**Consultation Response from Mike Hibbert,
KC Waste Strategy(Refuse & Recycling)**

2023/93464 Land at, Lingards Road, Slaithwaite, Huddersfield, HD7 5HY

Date Responded: 12/12/2023.

Responding Ref: WPS 23-064

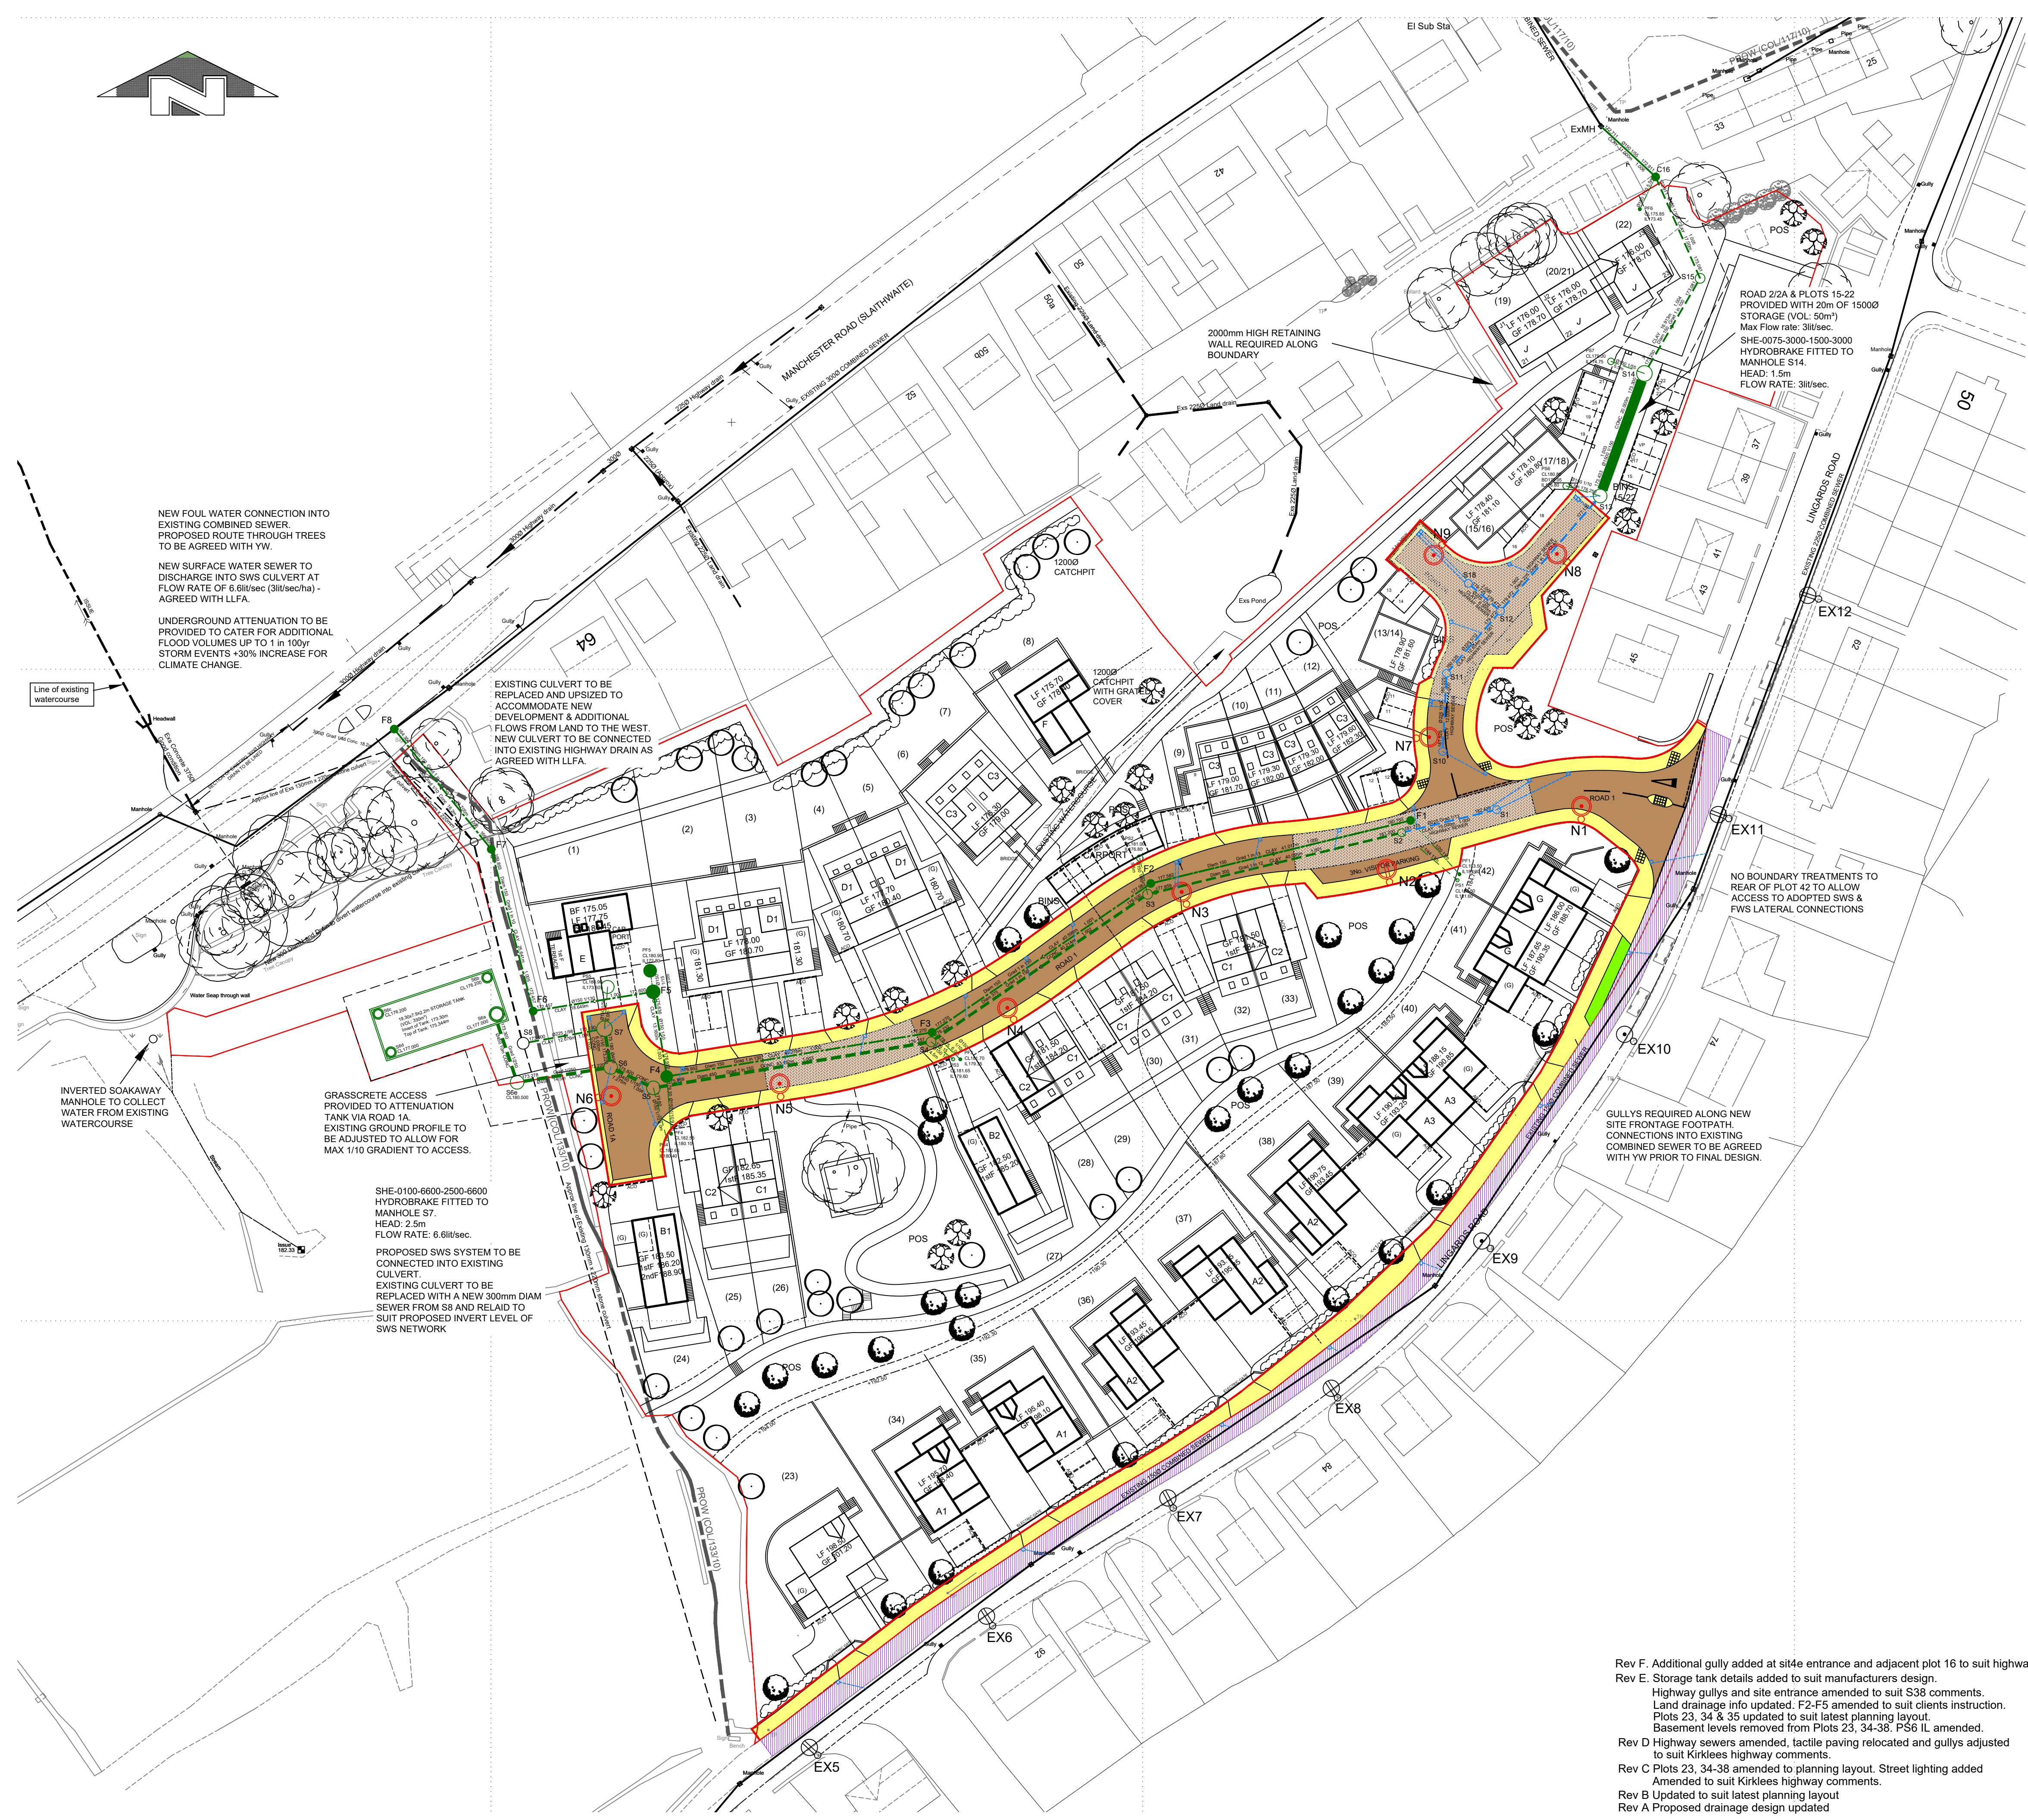
The plan is annotated, with the phasing for the site (in green) and both details of collections from properties along Lingards Road and the location of temporary bin collection point (in Red). for use during staged occupation by new residents.

- The Waste Collection Authority will not enter active construction sites with a Refuse Collection Vehicle (RCV). The rationale is to avoid damage to RCV's due to inadequate roadways, potential impact between RCV's or collection crew with contractors' plant/ delivery vehicles and remove the necessity for collection staff to undertake mandatory health and safety induction by the site manager.

- It is welcomed that the applicant will arrange waste collection from Plots 19-22 and transfer waste to the site entrance on collection day.
- The WCA would appreciate the opportunity to meet on site with the site manager to discuss and confirm requirements in relation to access and waste collection points once residents start to occupy properties.
- For future phases, if an RCV is entering a site to service properties or a temporary waste store, then there must be demarcation such that a turning head is fenced off from the active construction site. Long reversing manoeuvres by RCV's is a recognised safety risk for both collection staff and members of the public and must be avoided.

Once a meeting has taken place at commencement of construction to establish on site arrangements the WCA will be willing to confirm discharge of Condition 29.
